From: sean Tofts [REDACTED]
Sent: 17 September 2020 10:25
To: Daun Johnson <Daun.Johnson@arun.gov.uk>
Subject: Re: FW: Request for further information A/151/20/OUT

Block Plan 1:2500 at A4 DRAWING 001

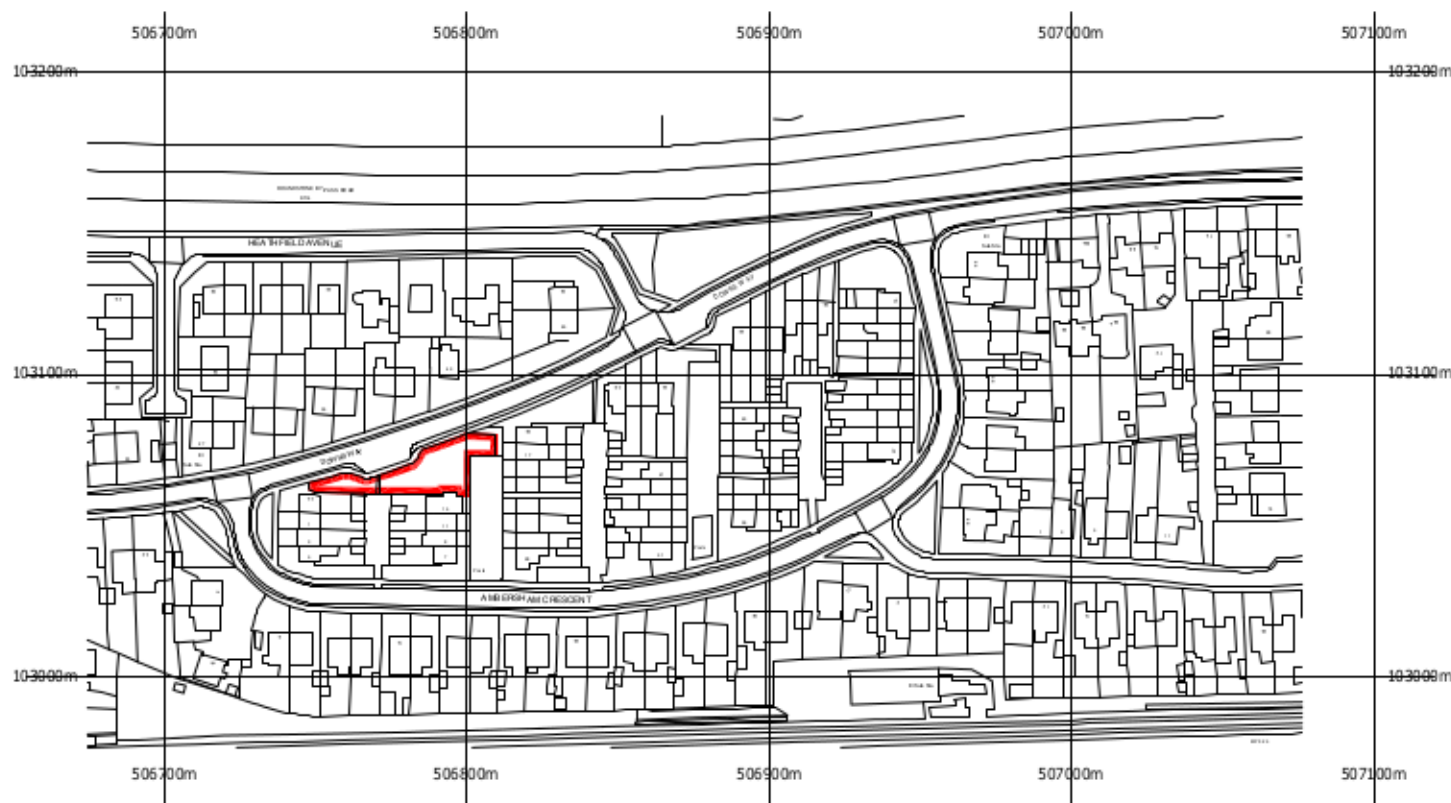
The block plan needs to show visibility splays since it's a new access into the site.

apologies for the chain email but as highlighted by the attachment; the visibility splays in the area are so high it is not a reasonable judgement to consider this to be an impediment to the validation of the planning application in my view. As indicated as an outline there may be negotiation, if approved with the Council to assess where the most appropriate location for an access would be but in all locations on the site visibility levels are higher than that which would be required.

Thank you for taking my call. In line with your requests I included the additional information you requested as of prior to today's update. If you could just review the planning portal guidance it suggests that access can be a reserved matter though I accept your points visibility splays would be something that the highways department can request if they deem it necessary.

The proposal put forward is indicative and therefore it would be inappropriate for me to fix one access point.
